**WENGER SHORT PLAT (SP-07-00007)
COMPLIANCE DOCUMENT**

PRELIMINARY APPROVAL CONDITIONS	APPLICANT RESPONSE	STAFF REVIEW
<p>1) BOTH SHEETS OF THE FINAL MYLARS SHALL REFLECT SHORT PLAT NUMBER SP-07-00007 AND AN ACCURATE LEGAL DESCRIPTION SHALL BE SHOWN ON THE FACE OF THE FINAL PLAT. ENGINEERS AND SURVEYORS NEED TO BE COGNIZANT OF ALL OF THE REQUIREMENTS RELATED TO FINAL PLATS (KCC 16.20) AND SURVEY DATA AND DEDICATIONS (KCC 16.24). THE FINAL PLAT MUST BE SUBMITTED IN FULL CONFORMANCE WITH THESE CHAPTERS OF KITTITAS COUNTY CODE: <u>NON-COMPLIANT MYLARS WILL BE REJECTED AND RETURNED TO THE APPLICANT.</u></p>	<p>SHORT PLAT NUMBER HAS BEEN ADDED TO FINAL SHORT PLAT.</p> <p>SHORT PLAT IS IN FULL CONFORMANCE WITH COUNTY CODE.</p>	<p>SP-07-00007 on Face of Final Plat</p>
<p>2) ENVIRONMENTAL AND STATUTORY REVIEW MAY BE REQUIRED FOR ALL CURRENT AND FUTURE DEVELOPMENT, CONSTRUCTION, AND IMPROVEMENTS. THE APPLICANT AND/OR ALL FUTURE OWNERS OF ANY LOT OR LOTS WITHIN THIS SUBDIVISION ARE RESPONSIBLE FOR COMPLIANCE WITH ALL APPLICABLE LOCAL, STATE, AND FEDERAL RULES, REQUIREMENTS, CODES, AND REGULATIONS. IT IS INCUMBENT UPON SAID APPLICANTS AND FUTURE OWNERS TO INVESTIGATE FOR, AND OBTAIN FROM TH

KITTITAS COUNTY		WASHINGTON	
DWN BY	DATE	JOB NO.	
S.W./G.W.	08/2018	06305	
CHKD BY	SCALE	SHEET	
M.K.K./S.W.	N/A	2 OF 3

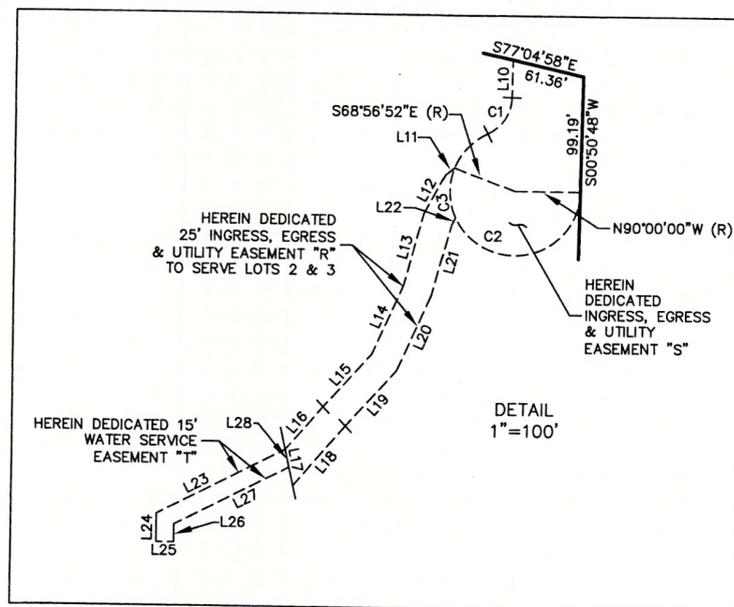
<p>3) ALL WATER PROPOSED TO BE USED MUST BE OBTAINED FROM A WATER BUDGET NEUTRAL SOURCE AND MEET CONDITIONS OF KCC 13.35.</p>	<p>SEE MITIGATION WATER ALLOCATION DOCUMENT AFN# 201805180082 (COPY OF DOCUMENT WILL BE INCLUDED WITH THE SUBMITTAL OF THIS COMPLIANCE DOCUMENT)</p>	<p>Recorded Document Submitted</p>
<p>4) THE CURRENT YEAR'S TAXES MUST BE PAID IN FULL ON ALL TAX PARCELS INVOLVED IN THIS LAND USE ACTION AS REQUIRED BY WASHINGTON STATE LAW (RCWS 84.40-042 & 84.56.345).</p>	<p>TAXES WILL BE PAID IN FULL FOR 2018</p>	<p>Taxes not yet paid, No MBSW to check</p>
<p><u>5) THE FOLLOWING PLAT NOTES SHALL BE RECORDED ON THE FINAL MYLAR DRAWINGS:</u></p> <p>A) ALL DEVELOPMENT MUST COMPLY WITH INTERNATIONAL FIRE CODE.</p>	<p>OK - SEE NOTE 11 ON SHEET 2 OF 3 OF FINAL SHORT PLAT.</p>	<p>Plat note listed</p>
<p>B) ALL WATER PROPOSED TO BE USED MUST BE OBTAINED FROM A WATER BUDGET NEUTRAL SOURCE AND MEET CONDITIONS OF KCC 13.35.</p>	<p>OK - SEE NOTE 12 ON SHEET 2 OF 3 OF FINAL SHORT PLAT.</p>	<p>Plat note listed</p>

WENGER SHORT PLAT - SP-07-00007

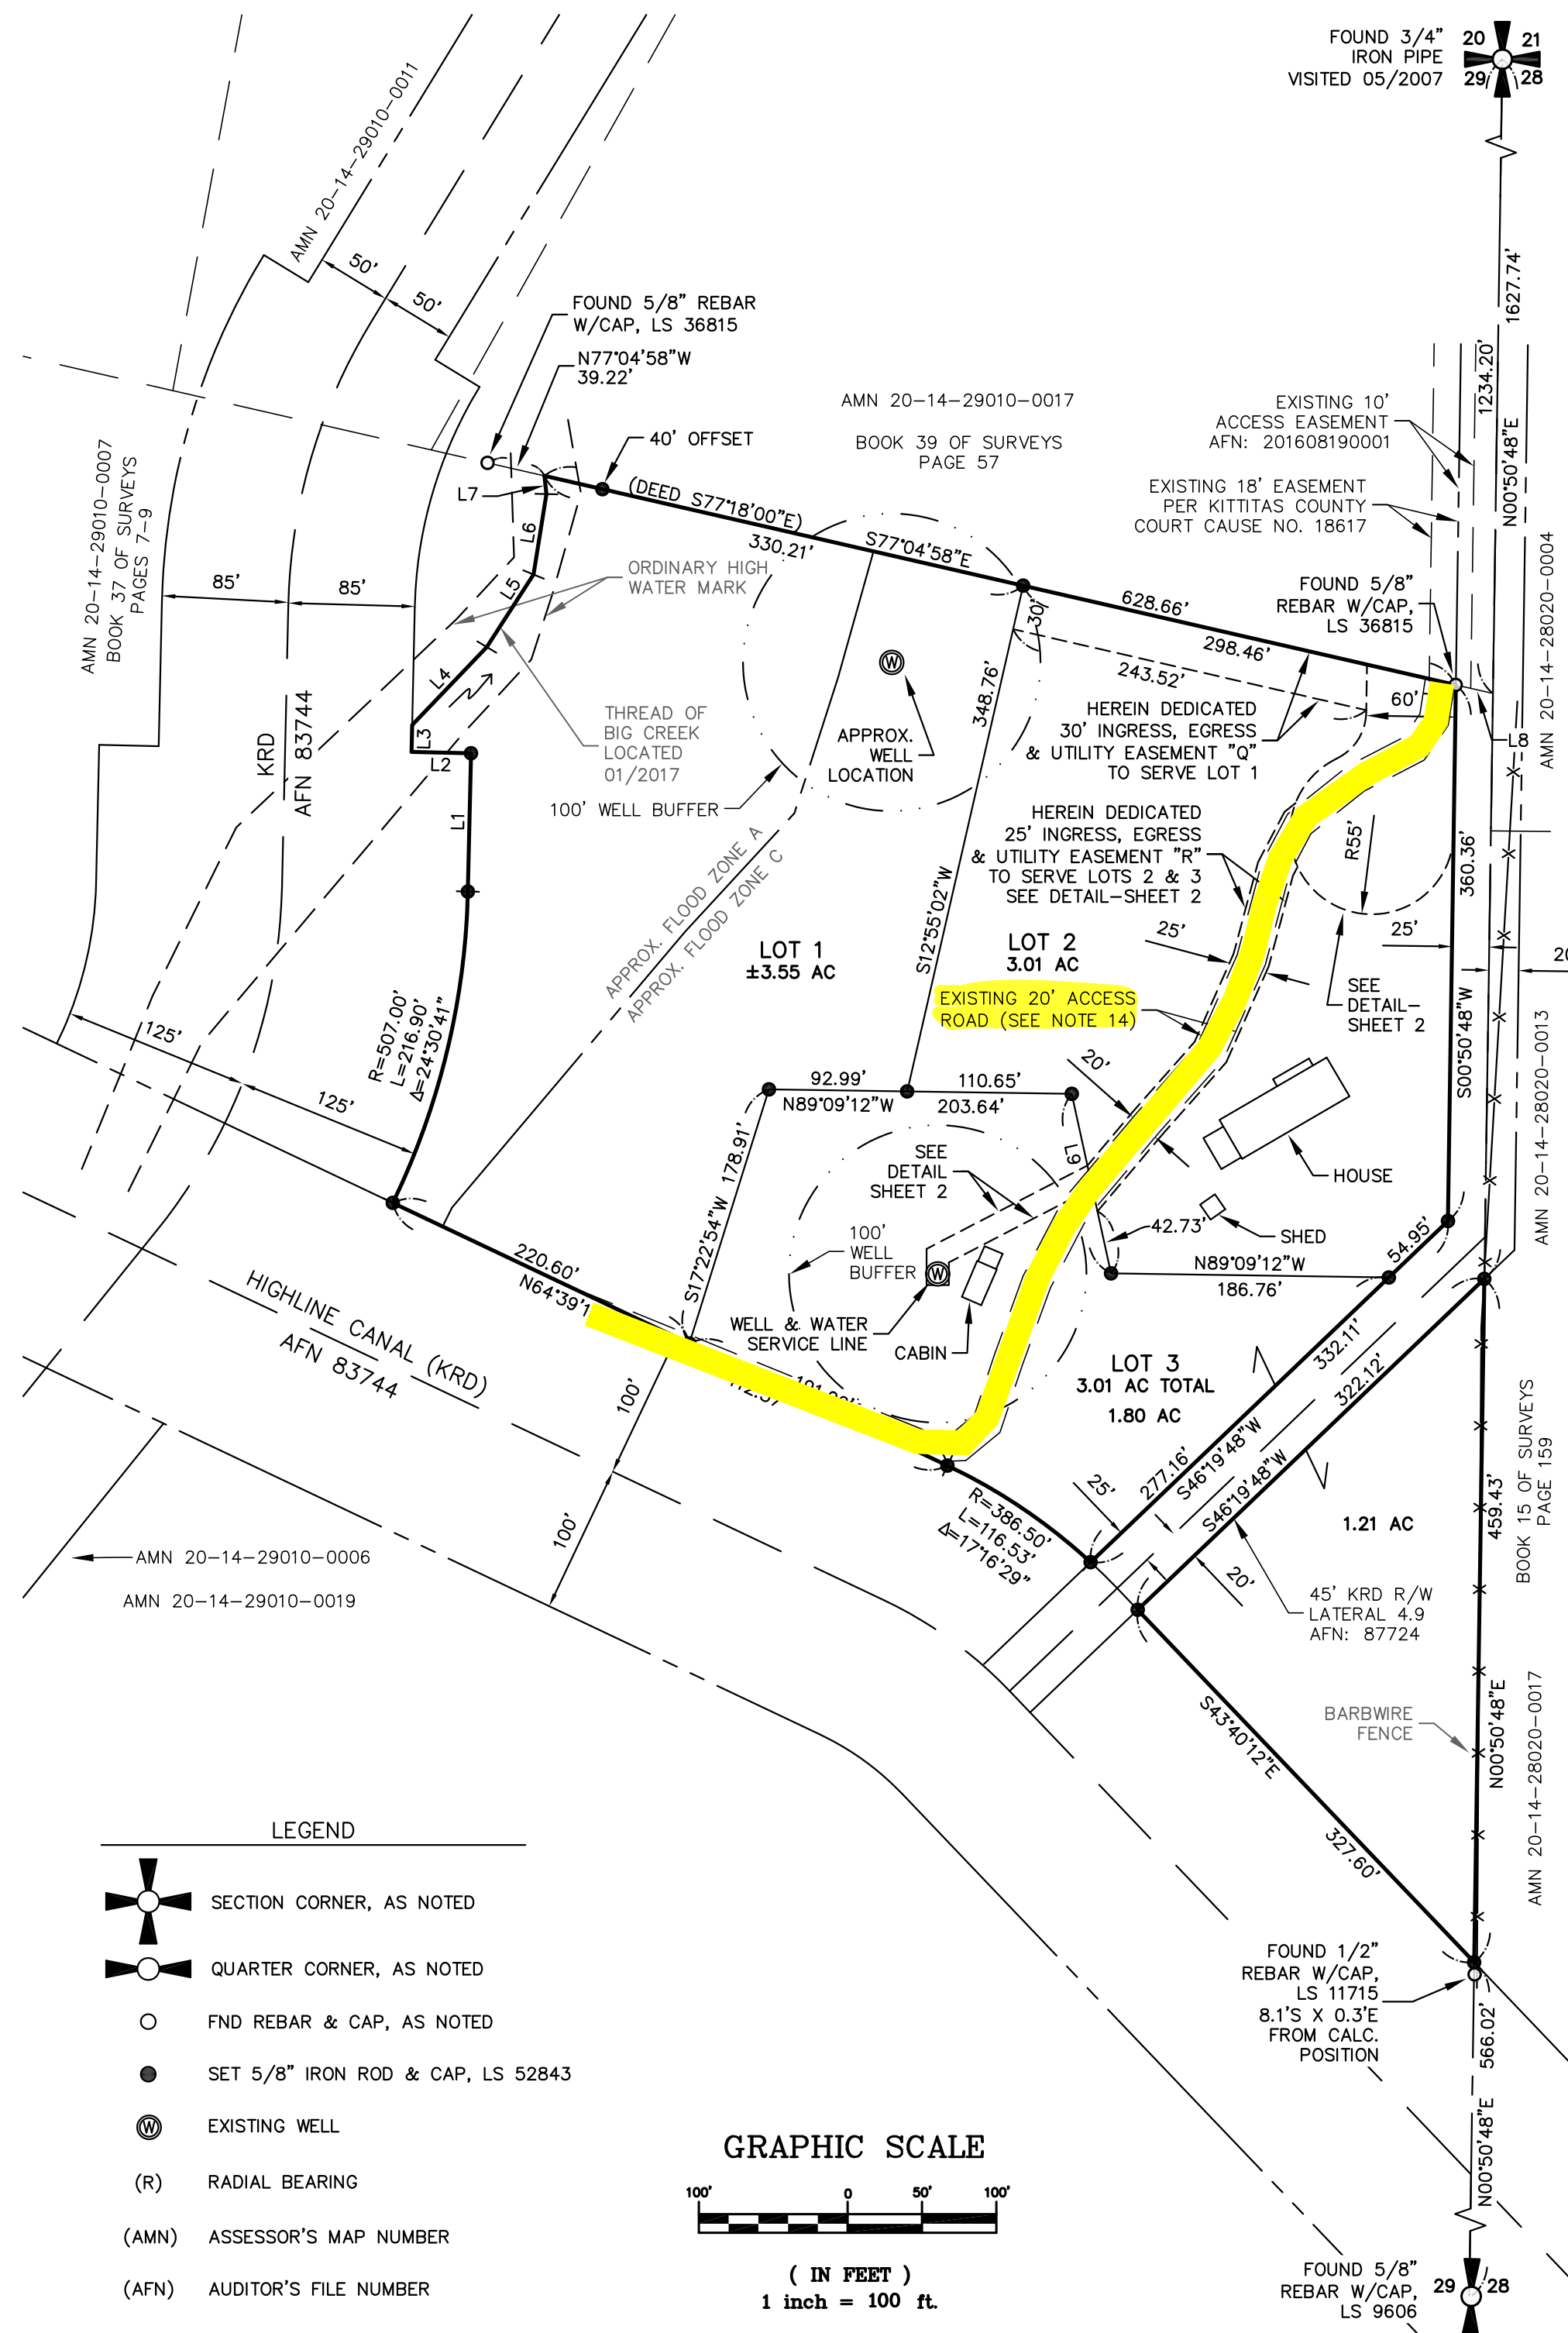
<p>B) PRIVATE ROAD CERTIFICATION: PRIVATE ROADS SERVING ANY OF THE LOTS WITHIN THIS DEVELOPMENT SHALL BE INSPECTED AND CERTIFIED BY A LICENSED PROFESSIONAL ENGINEER FOR CONFORMANCE WITH KITTITAS COUNTY ROAD STANDARDS, 9/6/05 EDITION. KITTITAS COUNTY PUBLIC WORKS SHALL REQUIRE THIS ROAD CERTIFICATION TO BE COMPLETED PRIOR TO THE ISSUANCE OF A BUILDING PERMIT FOR ANY OF THE STRUCTURES WITHIN THE PROPOSED PLAT.</p>	<p>NOTED</p>	<p>OK</p>
<p>C) ROAD VARIANCE: THIS SHORT PLAT IS SUBJECT TO THE CONDITIONS OF ROAD VARIANCE 14-09, WHICH ALLOWS A REDUCED ROAD AND EASEMENT WIDTH BUT REQUIRES A REVISED AGREEMENT FROM USBR PRIOR TO FINAL APPROVAL.</p>	<p>NOTED</p>	<p>No Revised agreement submitted</p>
<p>D) FINAL PLAT: THE FOLLOWING ITEMS MUST BE SHOWN ON THE FINAL PLAT:</p> <ul style="list-style-type: none"> i) 100-YEAR FLOODPLAIN ii) SHORELINE JURISDICTION iii) BIG CREEK iv) KRDL LATERAL BOUNDARIES v) EASEMENT AND DRIVEWAY SERVING PARCEL 616536 	<ul style="list-style-type: none"> i) SEE SHEET 1 OF 3 ii) SEE SHEET 1 OF 3 iii) SEE SHEET 1 OF 3 iv) SEE SHEET 1 OF 3 v) SEE SHEET 1 OF 3 & SEE NOTE 14 ON SHEET 2 OF 3 	<p>Floodplain boundary: Flood plain needs to be shown, not flood zone boundaries. Shorelines Not OK- Shows OHWM but not shoreline buffer Big Creek: property line boundary halfway into creek shown, but centerline does not continue Easement not shown as continuing to P# 616536</p>
